From: Simon Davis
Sent: 18 September 2026 10:40
To: Planning Scanning
Subject: FW: P2193i - Yapton Y/80/25/S73

From: Simon Davis
Sent: 16 September 2026 15:06
To: 'Paul Carnell' [REDACTED]
Subject: RE: P2193i - Yapton Y/80/25/S73

Subject: RE: P2193i - Yapton Y/80/25/S73 [Filed 10 Sep 2026 17:22]

Drawing:
Brue - Floor Plans
RVT - M4(3) HT DCC - 1

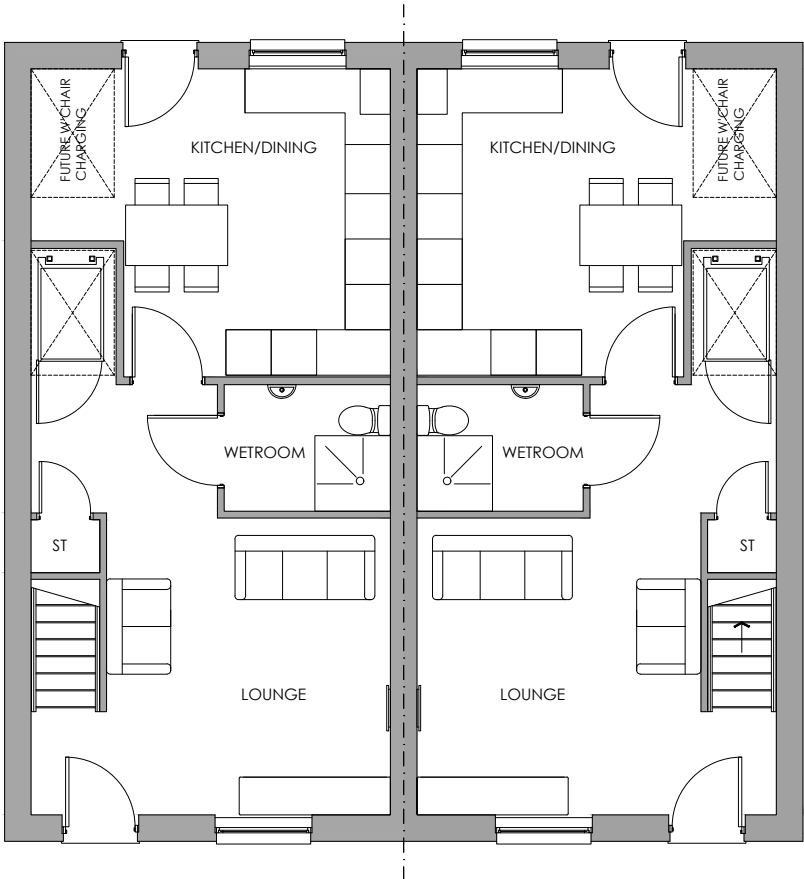
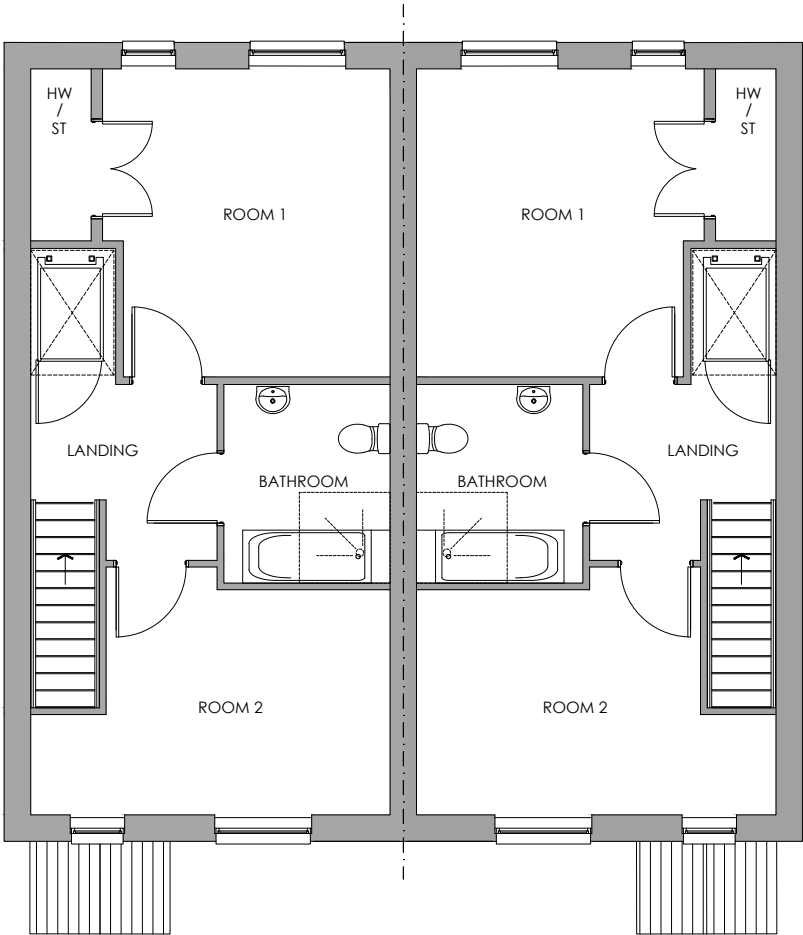
I can see that there are significant levels increases proposed in the north-west corner with for example an increase of 1.7m at plot 28 although this plot is not actually on the boundary. Plots 25 and 26 are on the boundary and are closely related to existing residential buildings in the strategic site to the North. It appears that the land here will be raised from around 6.1m with FFLs of 7.6m (1.47m increase) at plot 26 and 7.1m (1m increase) at plot 25. I note the approved FFL for the flatted building North of plot 26 was 6.215m. The increase for plot 26 is concerning given it will face ground and first floor lounge windows (and a ground floor garden) to these flats.

It is not clear as there are no proposed garden ground heights shown on the drawing, but I am assuming if plot 26's FFL is 7.6m, that its garden level will be raised accordingly, in which case there will be a considerable height difference between the site and the strat site to the North. How then will the raised earth be held up? Or is the garden to stay the same and steps provided to the ground floor level?

We have prepared section plans to address the below queries – I will include these as part of the updated pack of information to be submitted to you before the end of the week.
